Please ask for: Nicola Moore
Email: nicola.moore@arun.gov.uk
Telephone: Ext 37944
Our Ref: BE/134/21/PL
Your Ref:
Date: 13th August 2021

Application for Planning Permission

Development: Conversion of 1 No. dwelling into 2 No. dwellings. This application is in CIL Zone 4 and is CIL liable as new dwelling.
Location: 15 The Croft Bersted PO21 5TH

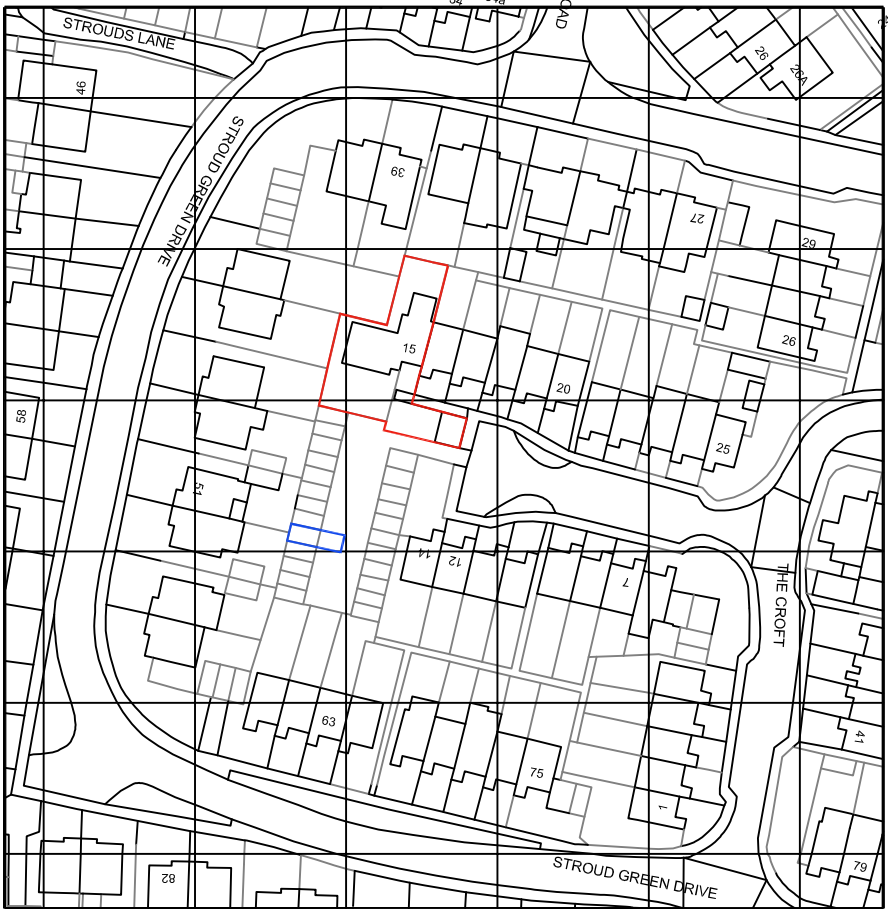
Location Plan

The Location Plan should include a North Point. Please amend accordingly and re submit. Further details of what must be included on the plan can be found in the Validation Requirements List.

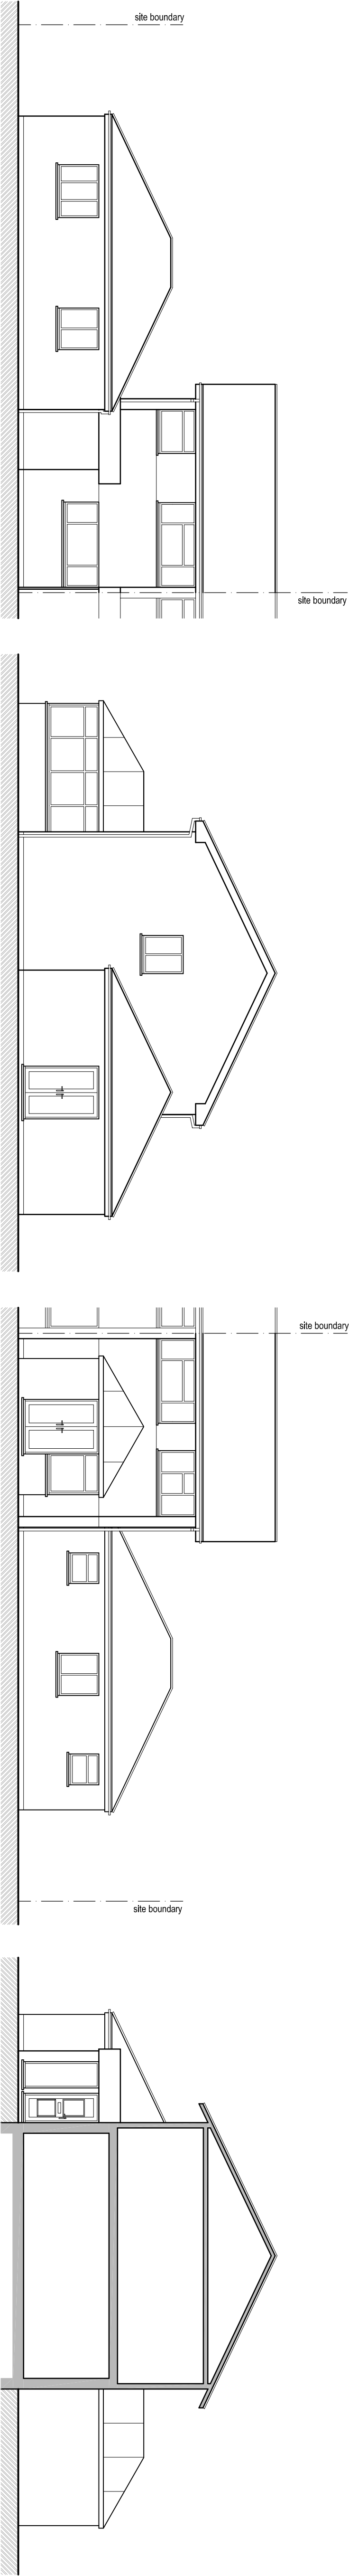
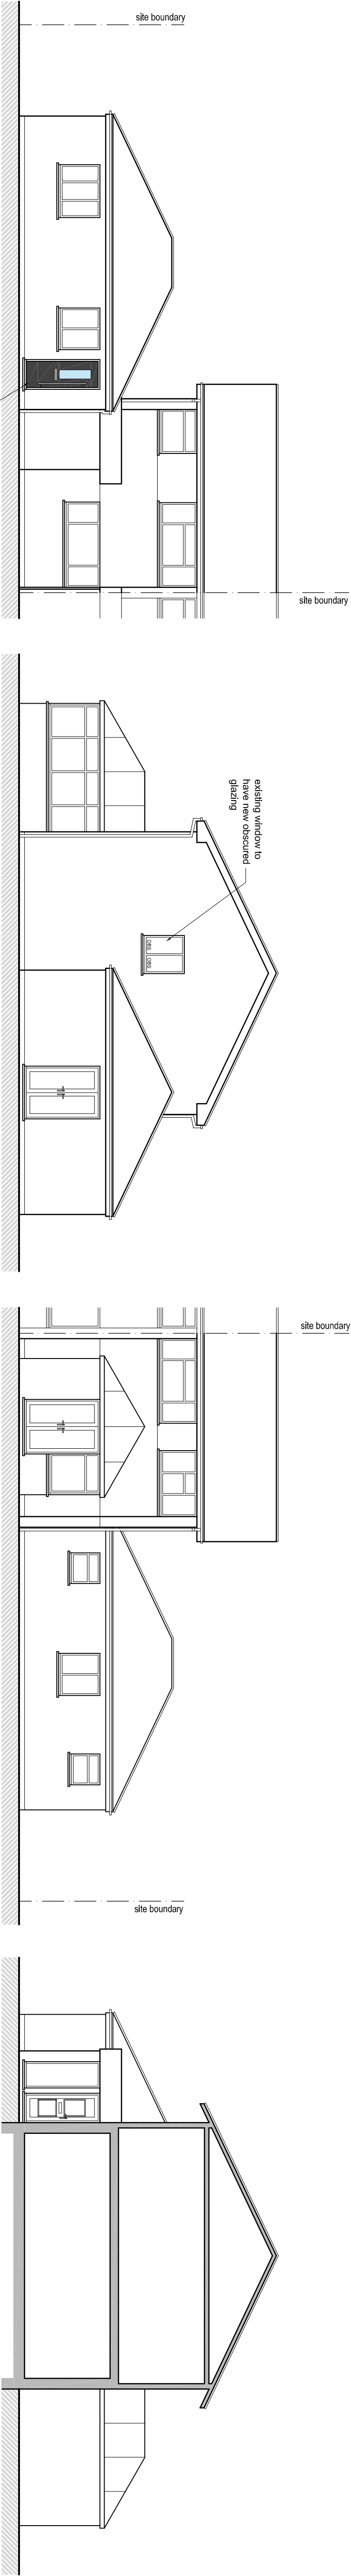
Elevations

The scale bar on the Existing & Proposed Elevations is 1:100, but in the title is 1:50. Please amend accordingly and re submit. Further details can be found in the Validation Requirements List.
